Application Reference: 3/2026/0423

Site: Langho Sports and Social Club, Northcote Road, Langho, BB6 8BE

Proposal: Proposed creation of a synthetic turf pitch with fencing, floodlighting, access path, changing block, and the extension and formalisation of the existing car park and ancillary equipment

Sport England Reference: PA/26/NW/RV/74220

PLAN VIEW

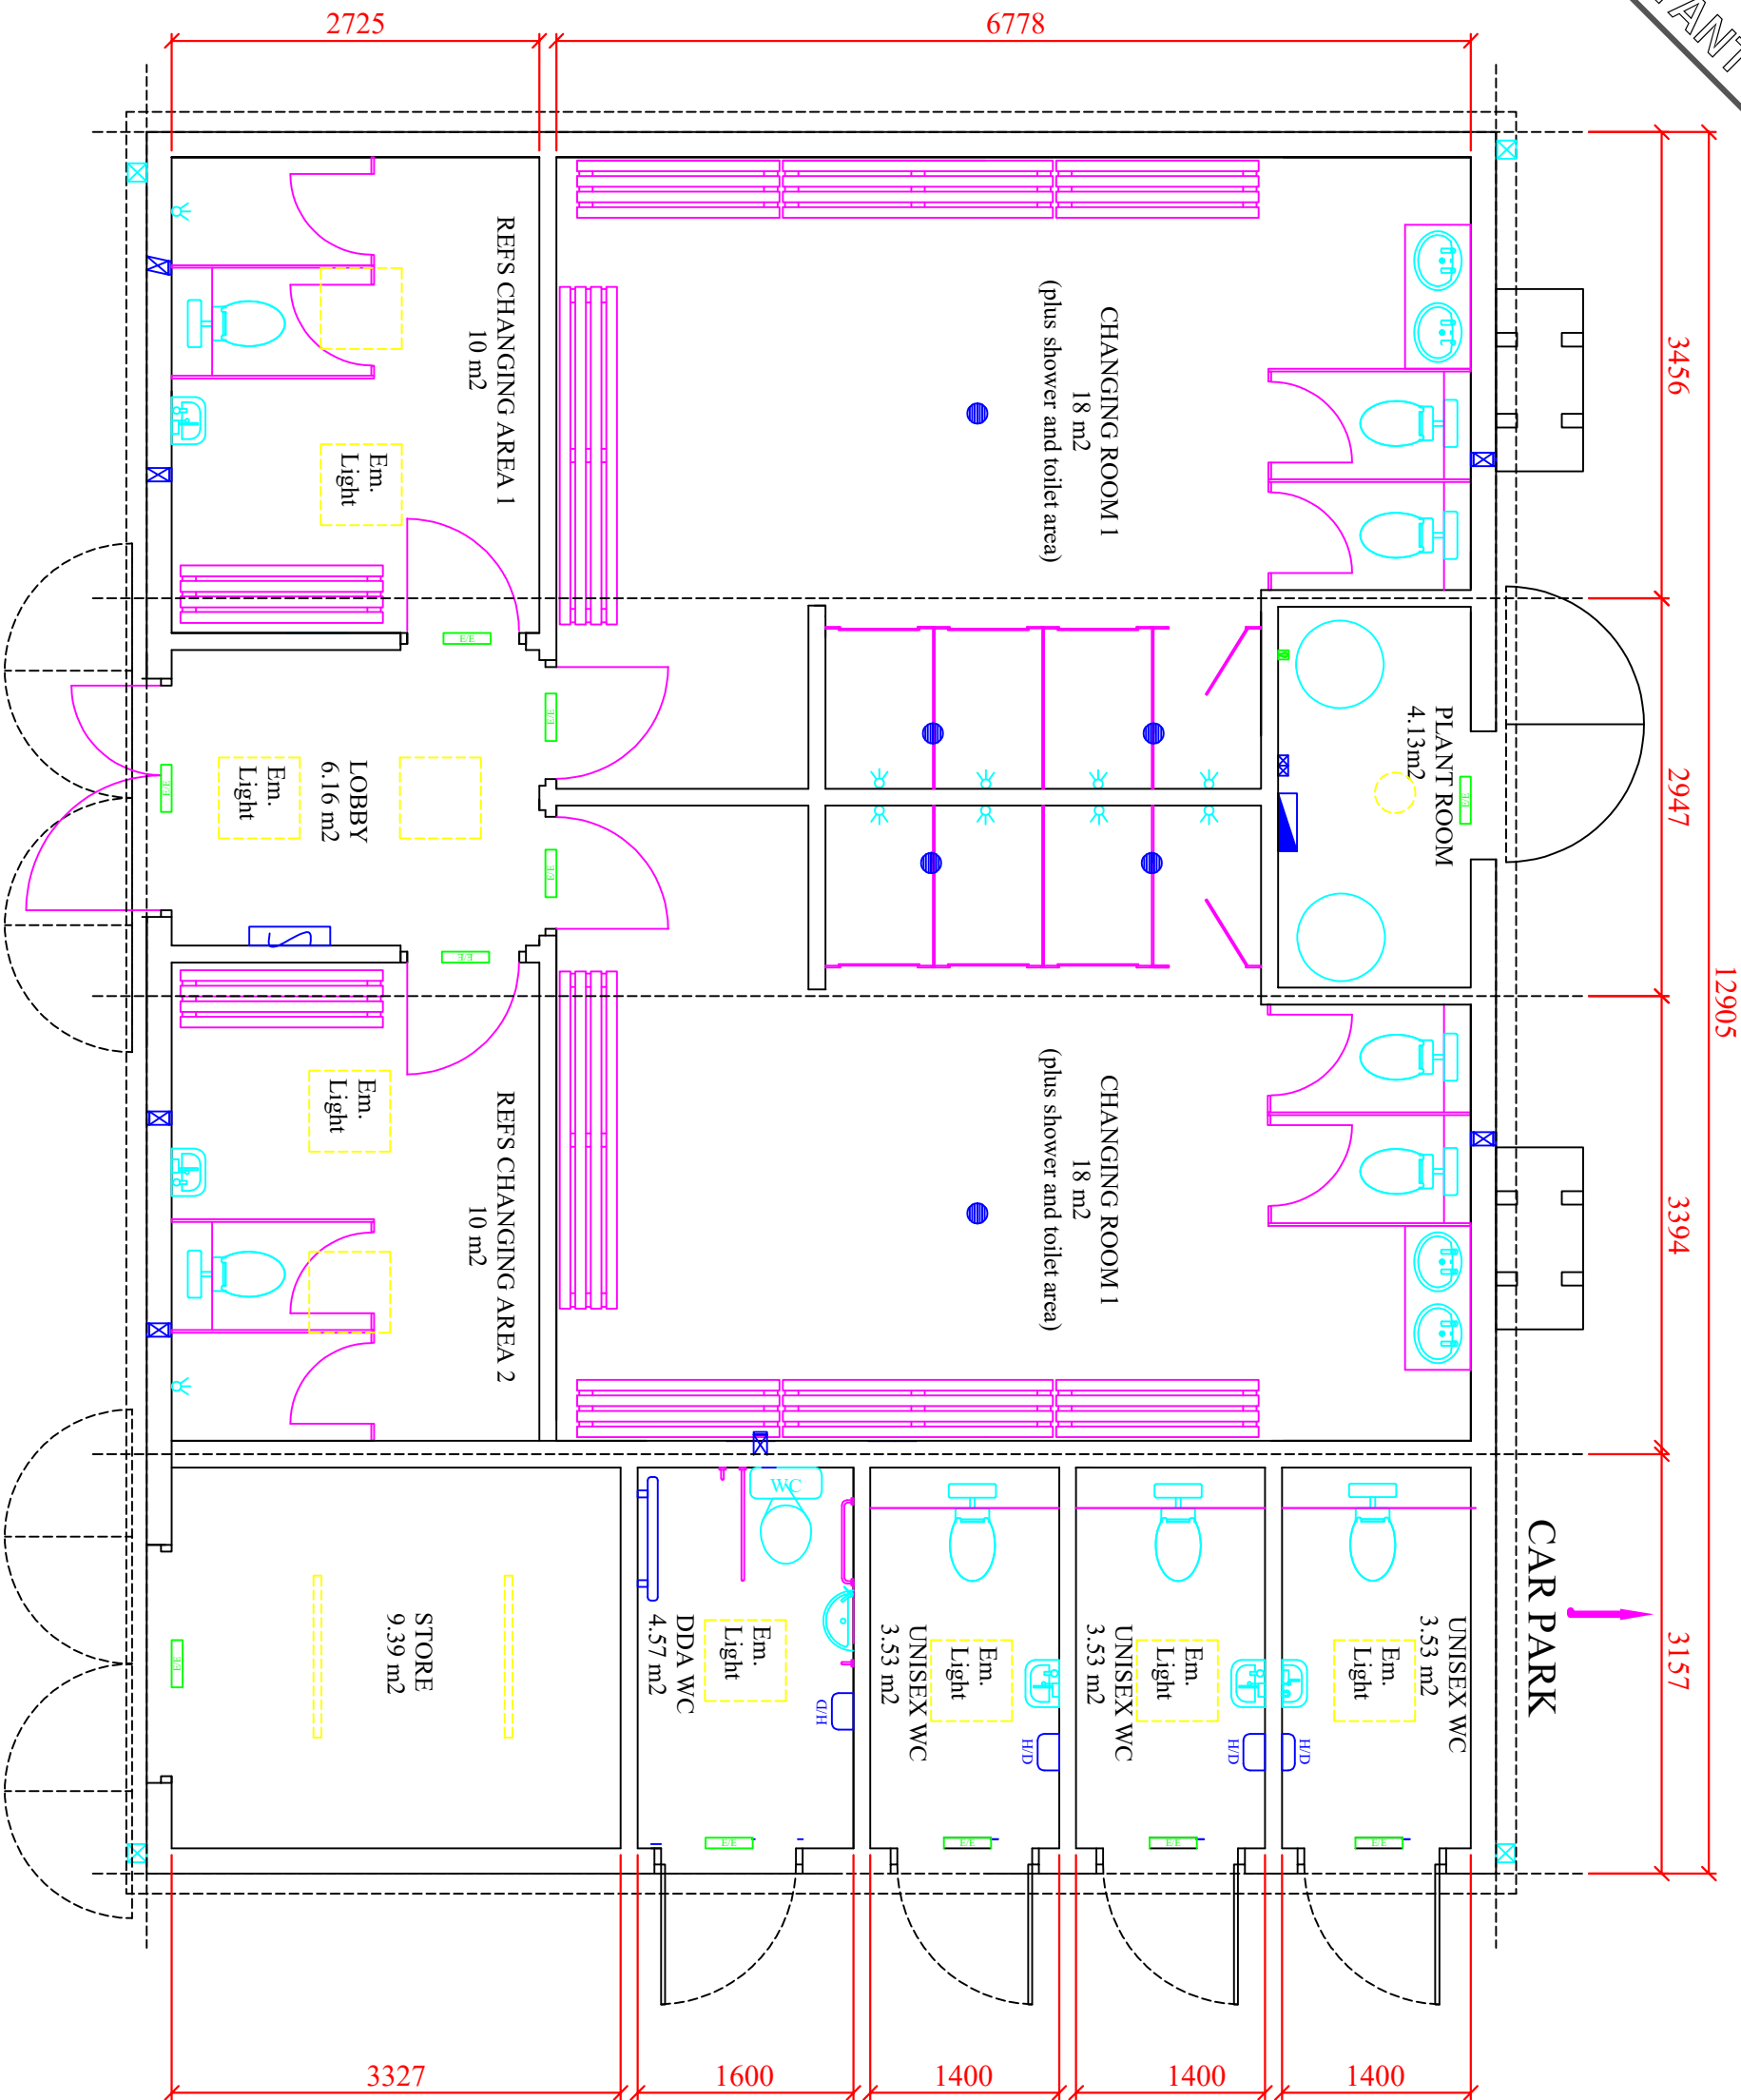
There is a direct line of sight into the officials' rooms and changing rooms, a privacy screen or dedicated lobby area should be included to mitigate safeguarding concerns privacy screen. If privacy screens can't be provided in the officials' changing rooms, a thumb-turn lock on the door would be required to protect privacy when officials are changing. Sport England advises this is addressed prior to determination.

Sport England strongly recommends that the issues relating to the line of sight and the visitor changing room window are addressed to protect users' privacy and resolve the identified safeguarding concerns.
